Your Ref: MP 08_0080 MOD 1
Our Ref: D18/5995
DA18062013585 BS

27 June 2018

Part 3A/State Significant Development Application - Modification Of Project Approval - Lyons Road, North Bonville

ROAD PROFILE 1 MAIN ENTRY ROAD

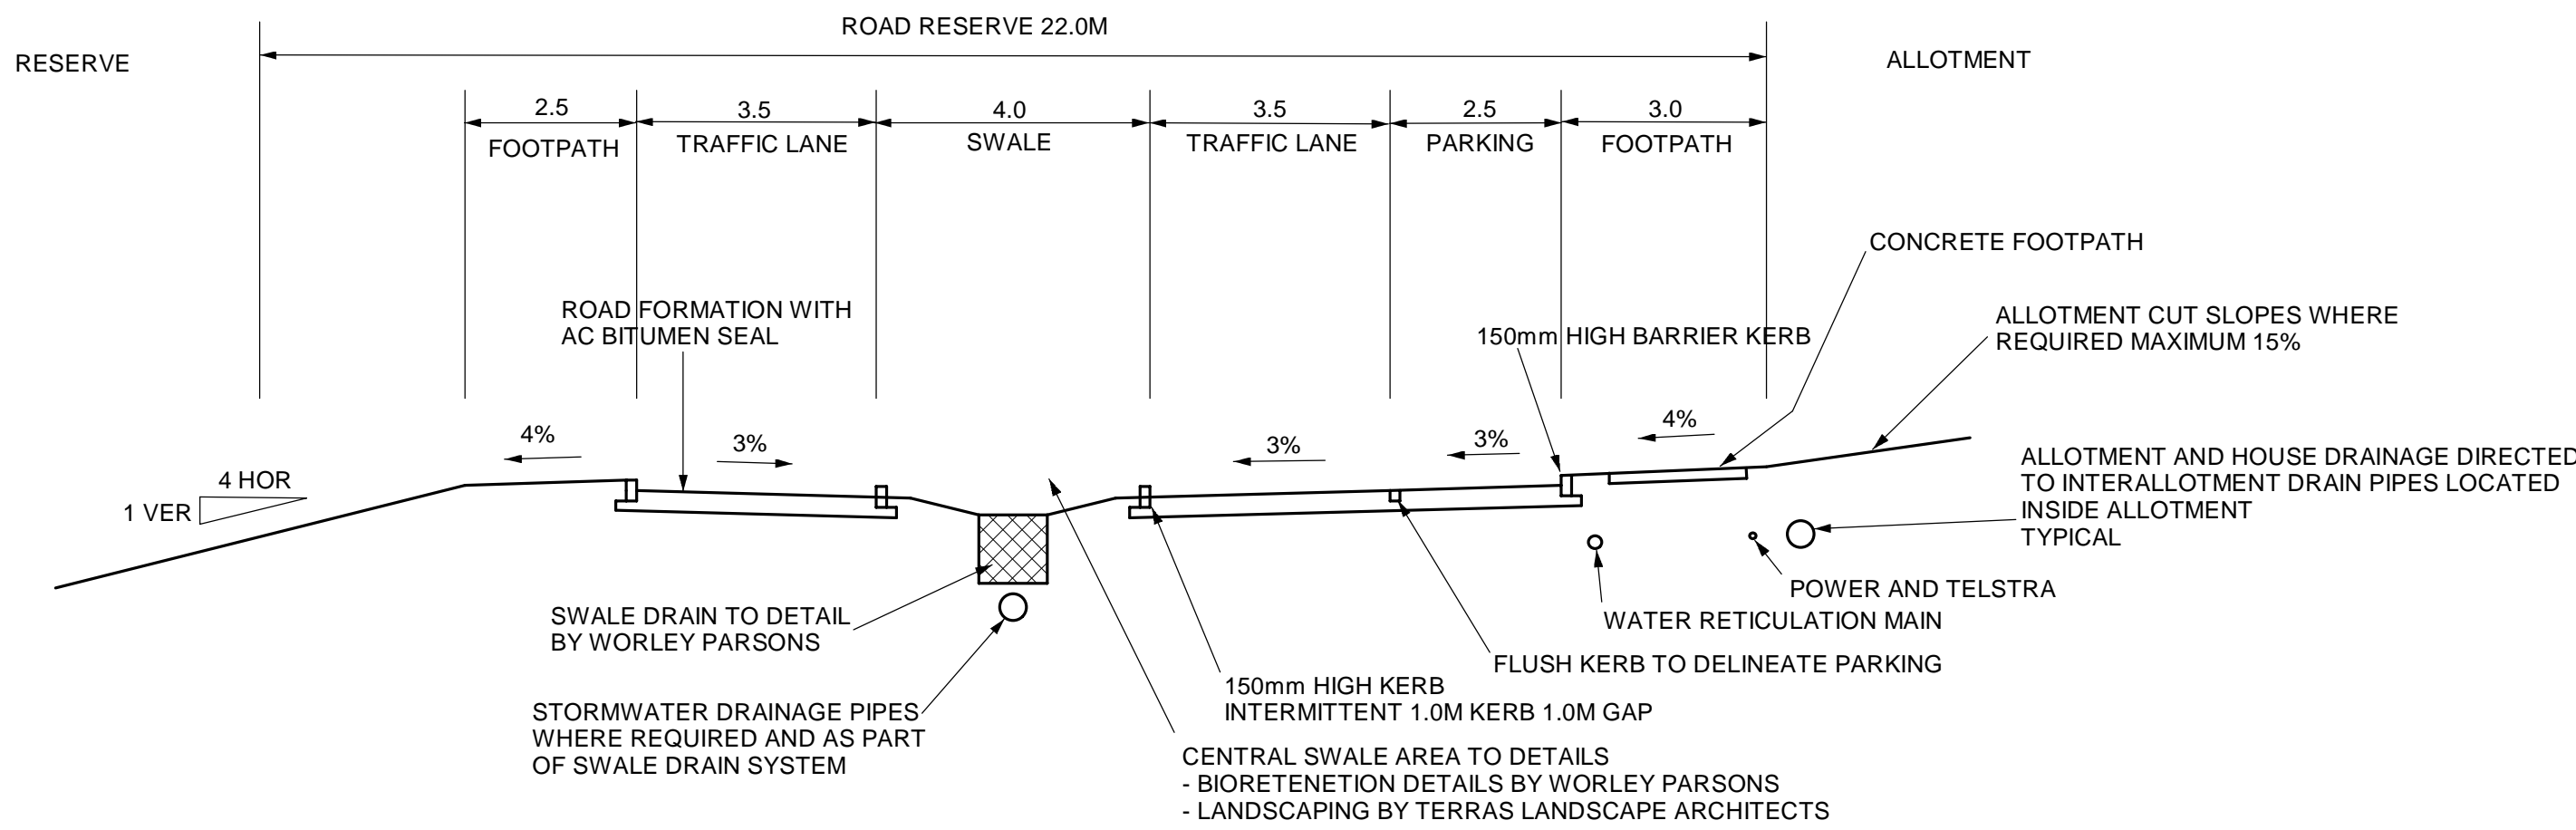
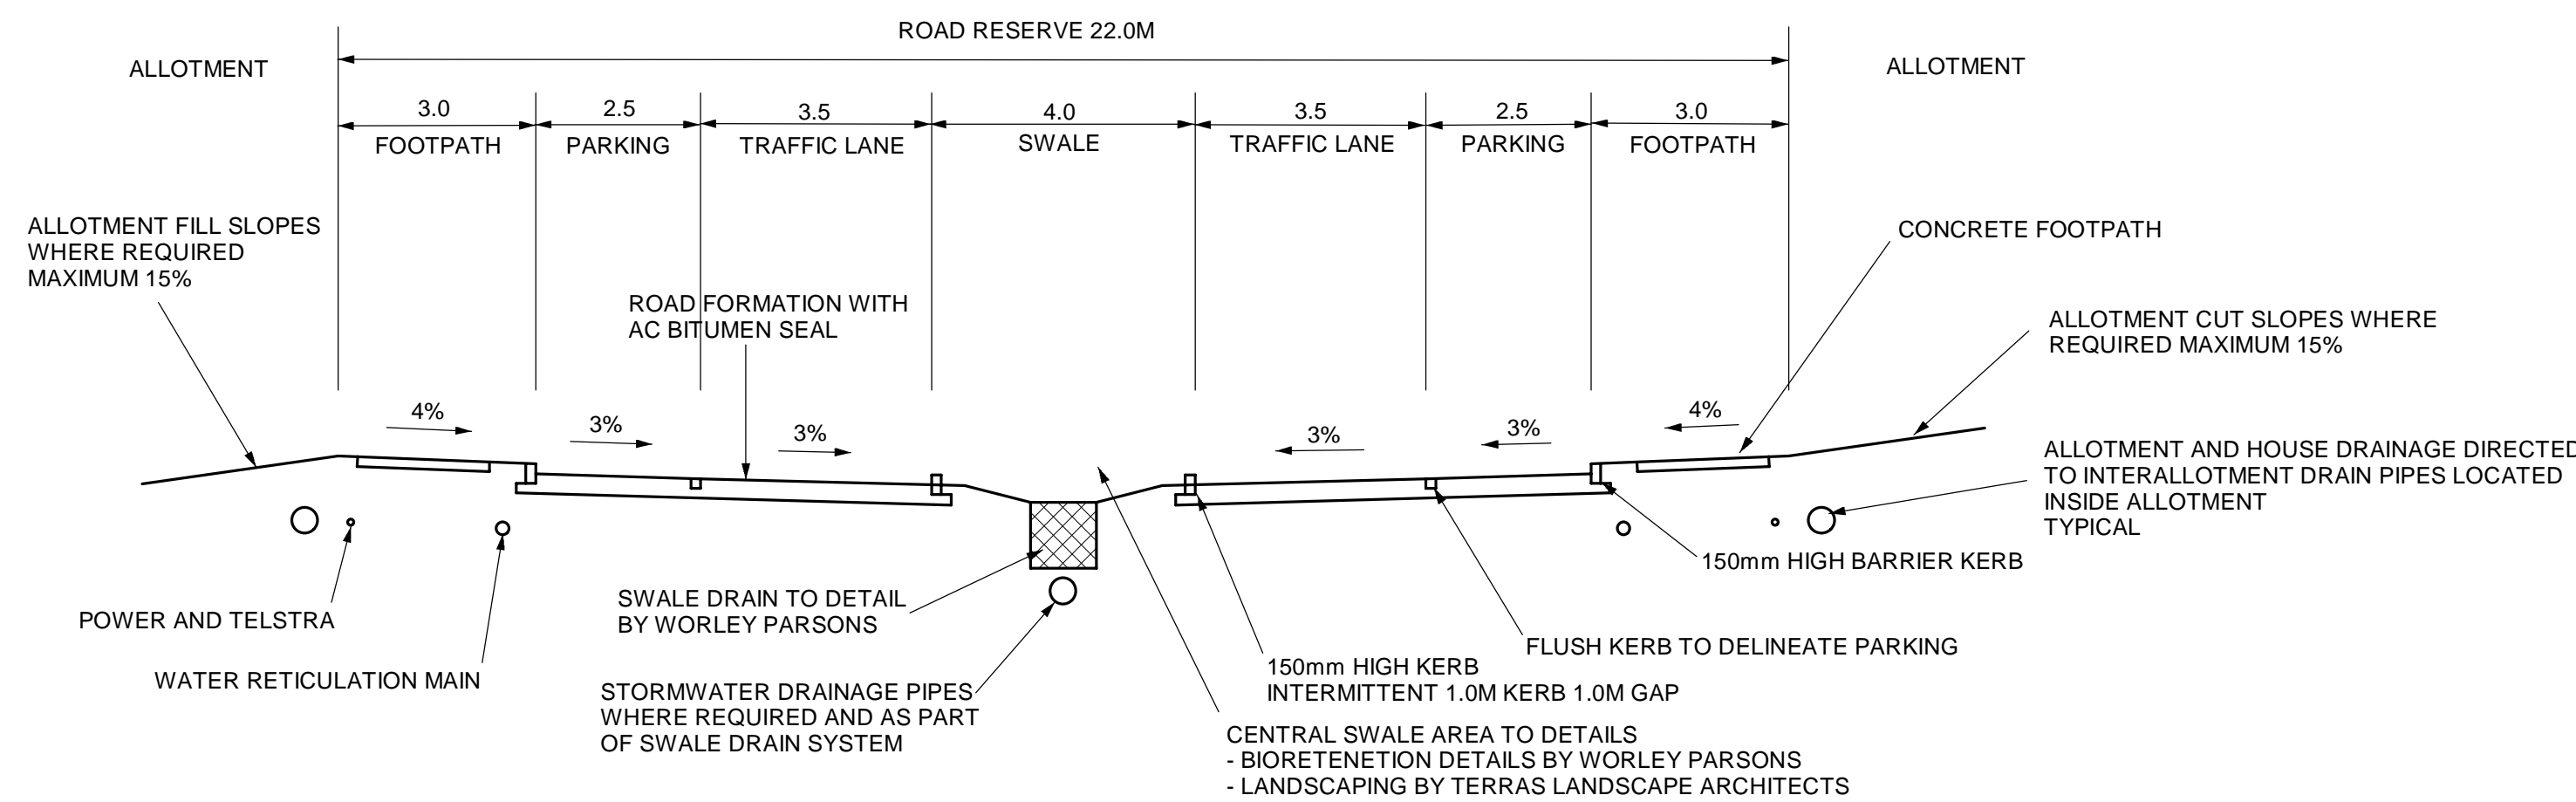
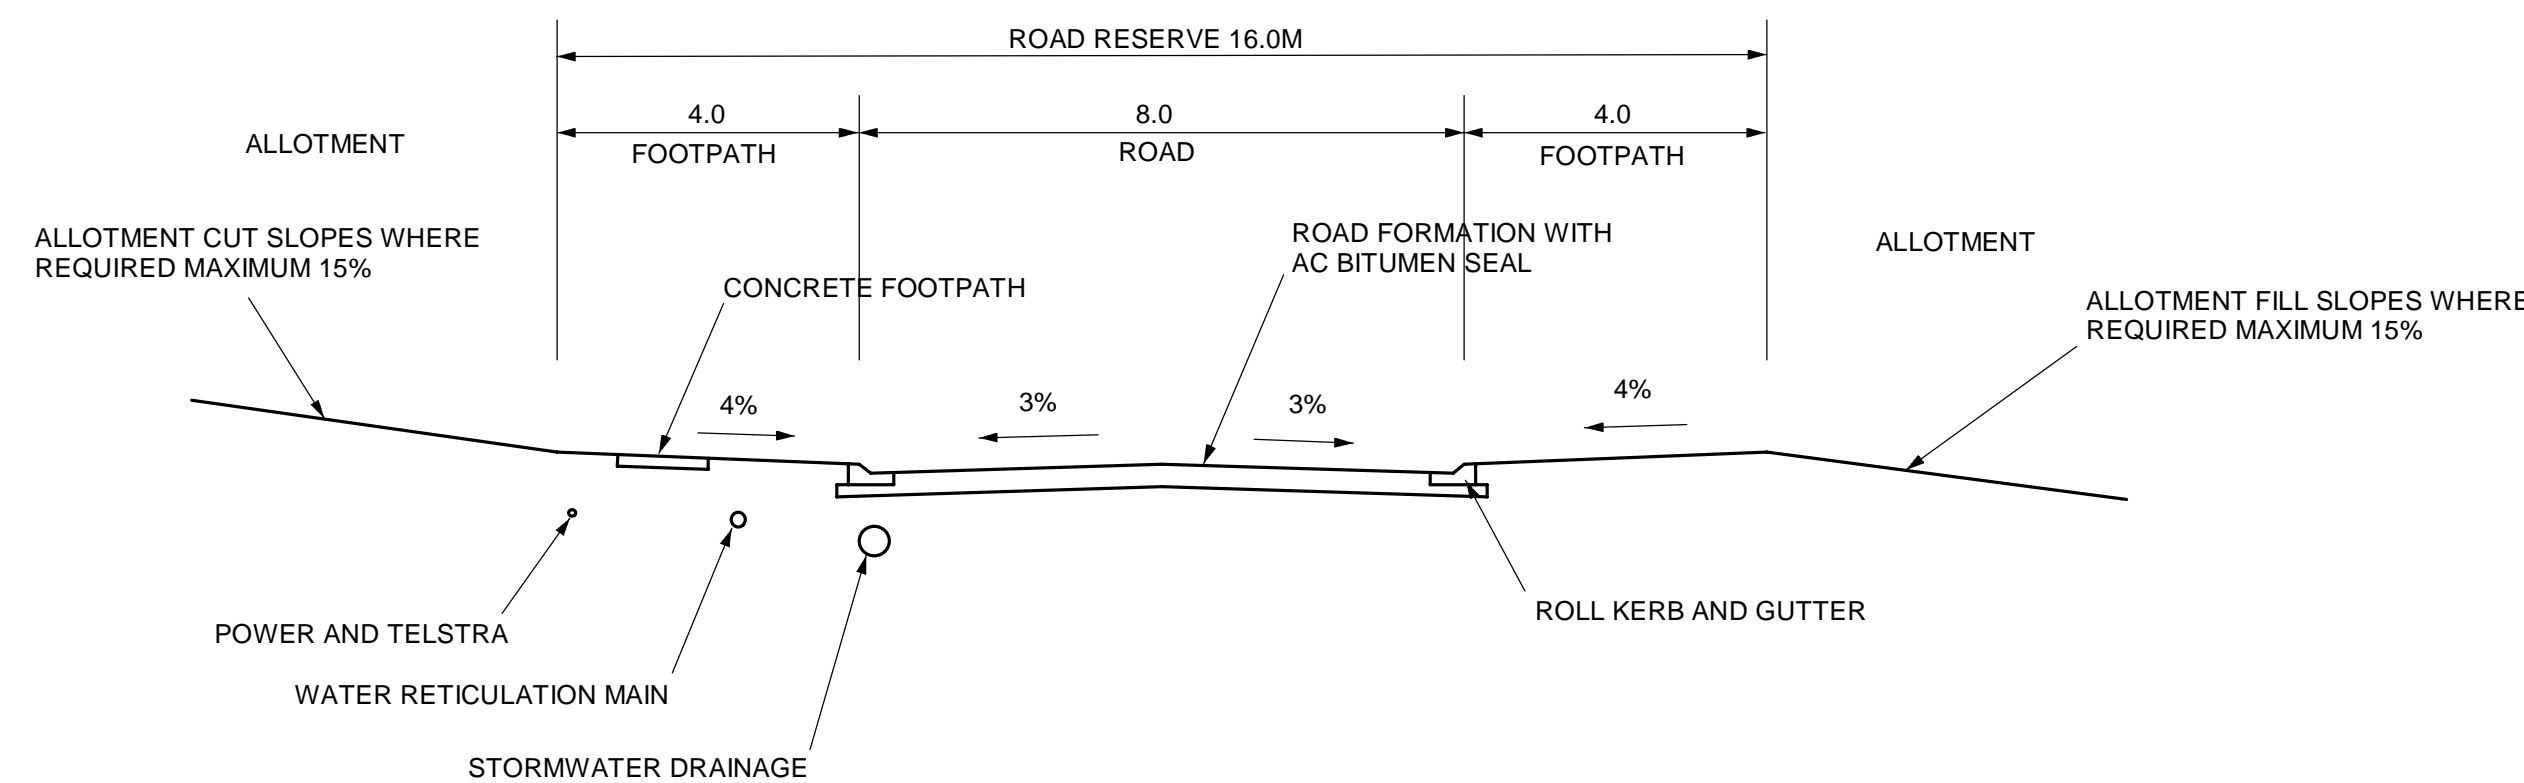
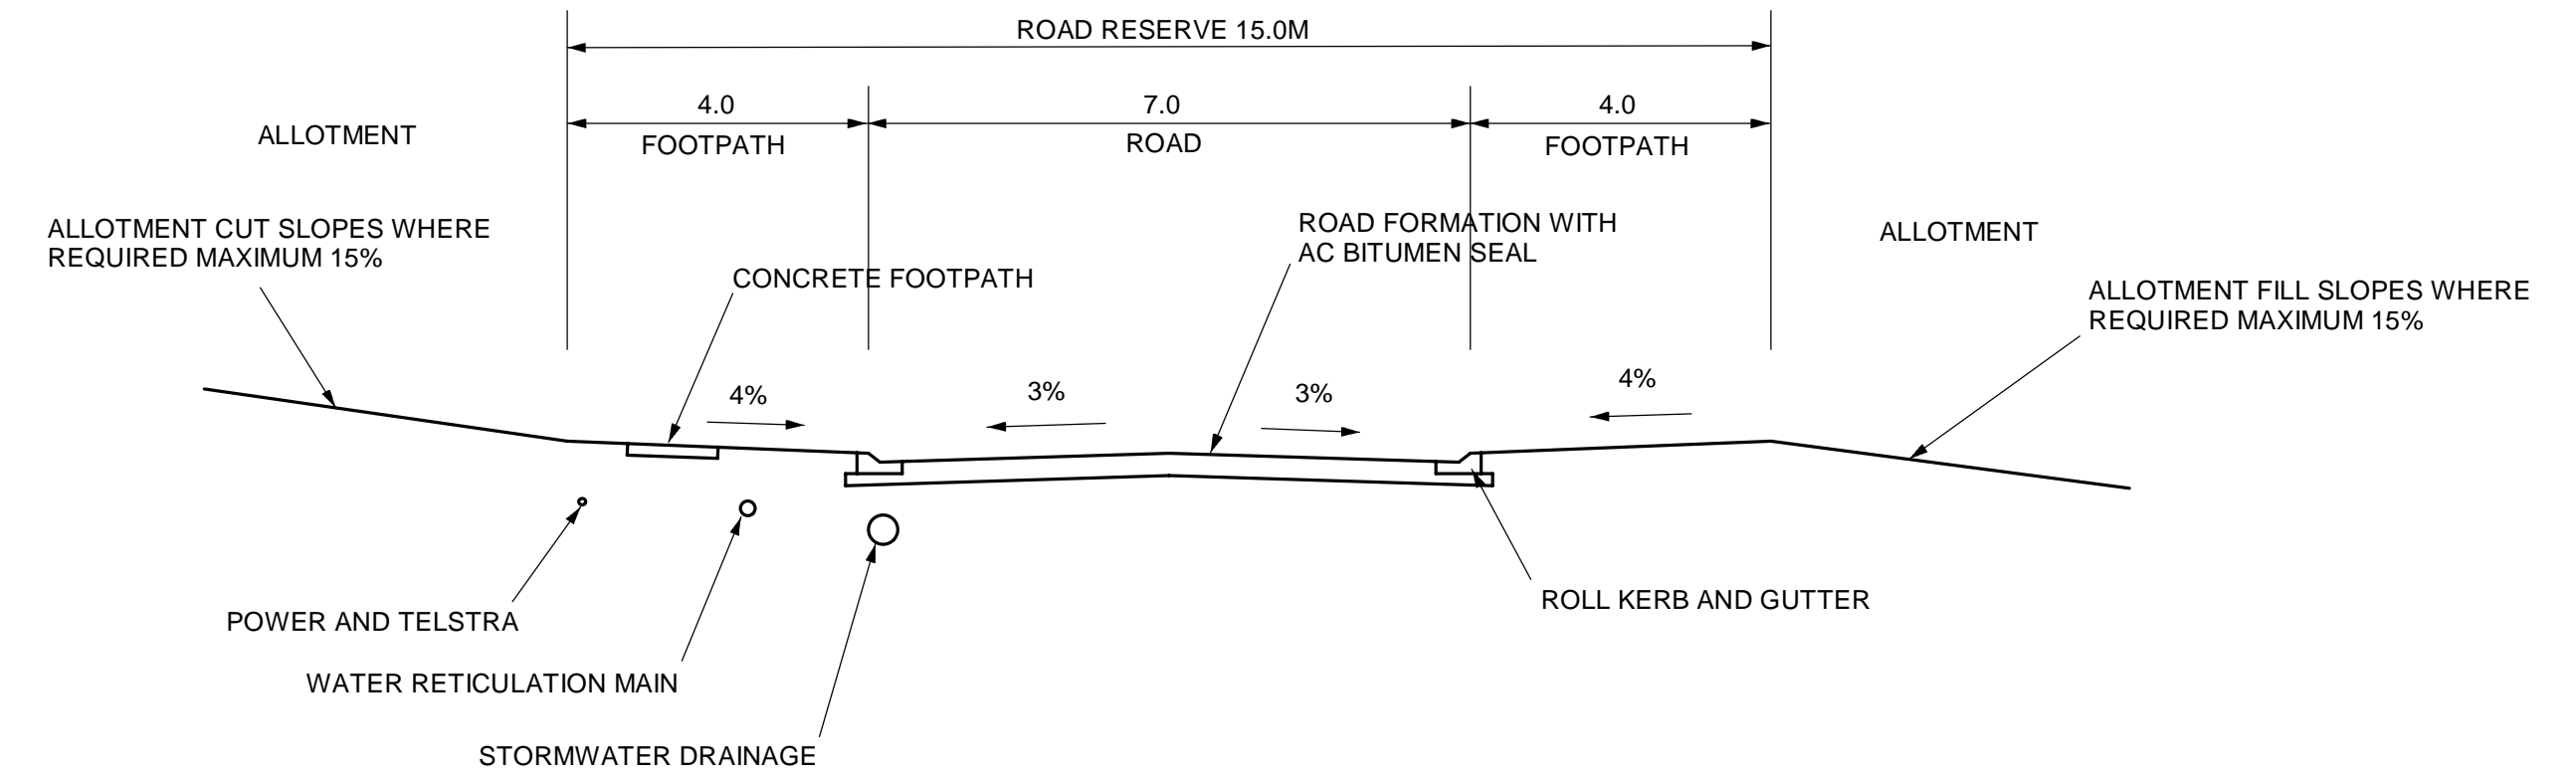
7. Public Road Access shall comply with section 4.1.3 (1) of Planning for Bush Fire Protection 2006.
8. Perimeter roads shall have a minimum carriageway width of 8 metres.

9. Non perimeter road widths shall comply with Table 4.1 in Planning for Bush Fire Protection 2006.
10. The fire trail system is to be connected to the public road system at frequent intervals of 200 metres or less.
